**RE: NM Mutual Home Office
Grading Plan
Engineer's Stamp Date: 09/28/17
Hydrology File: J13D206**

Based upon the information provided in your submittal received 01/04/2018, the Grading Plan **is not** approved for Grading Permit and Paving Permit. The following comments need to be addressed for approval of the above referenced project:

SECTION B-B

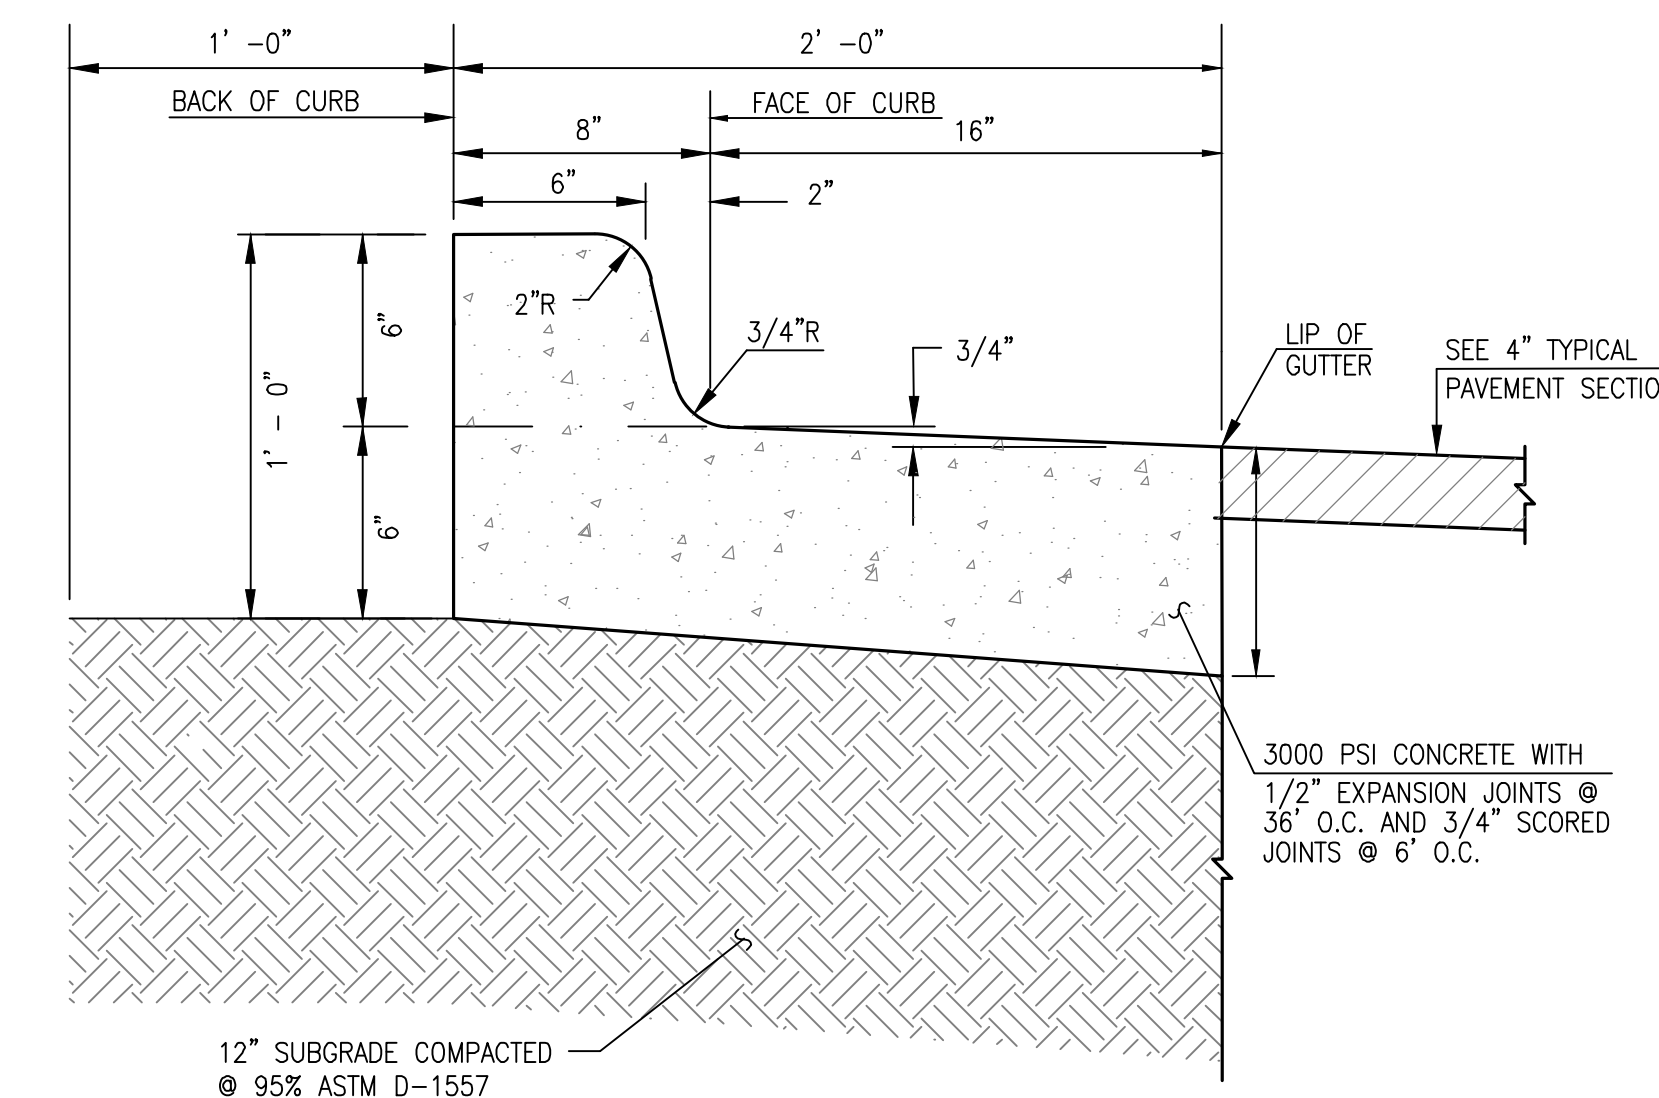
1. Please provide a cross section longitudinal along the proposed drive within the retention pond. Please show the slope of the drive (it appears that it goes from South to North) on the cross section and the slope of the 48-inch storm pipe.
2. How is the proposed drive's drainage getting to the retention pond? An example, providing a valley gutter at the connection between the existing paving and the proposed drive with a swale that directs the drainage to the pond?
